From: [Downes, Scott G \(DFW\)](#)
To: [Kelly Bacon \(CD\)](#)
Cc: [Torrey, Elizabeth M \(DFW\)](#); [Jeremy Johnston](#)
Subject: RE: LP-22-00001 Suncadia Phase 2 Division 7 - Notice of Application
Date: Wednesday, February 16, 2022 8:41:20 AM

Subject: LP-22-00001 Suncadia Phase 2 Division 7 - Notice of Application

CDS is requesting comment on the following Long Plat application LP-22-00001 Suncadia Dive 2 Phase 7. Links to the file materials can be found below. The comment period will end Monday, February 28, 2022. CDS will assume your agency does not wish to provide comment if not received by this date. Please let me know if you have any issues accessing the materials.

Site Development Plan Phase 2 Division 7

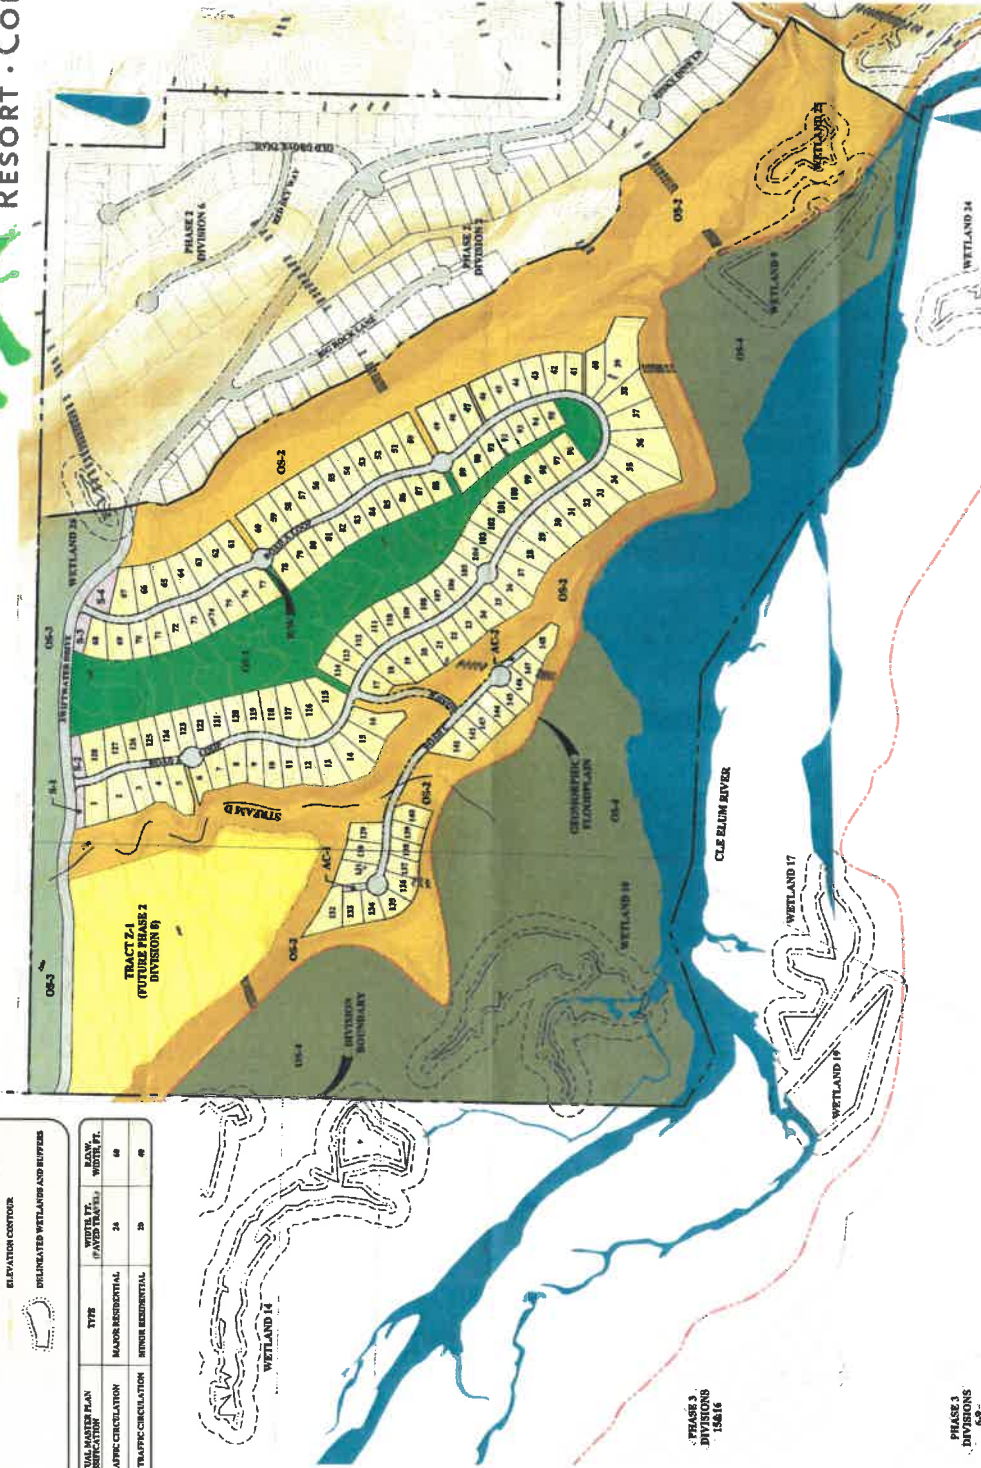
Thank you for the opportunity to review this project. WDFW reviewed the project and noticed that there is a new road planned over "Stream D". Stream D is also currently listed as a Type F (fish-bearing) stream. Thus to build the water crossing over the stream, the applicant will need to submit for an HPA from WDFW and the crossing design will need to be fish passable. WDFW is happy to help the applicant with technical advice on sizing and design of the structure and that is best done through a site visit. Please pass along my contact information to them so that we can set up a site visit to discuss and look at the proposed crossing when the timing is appropriate.
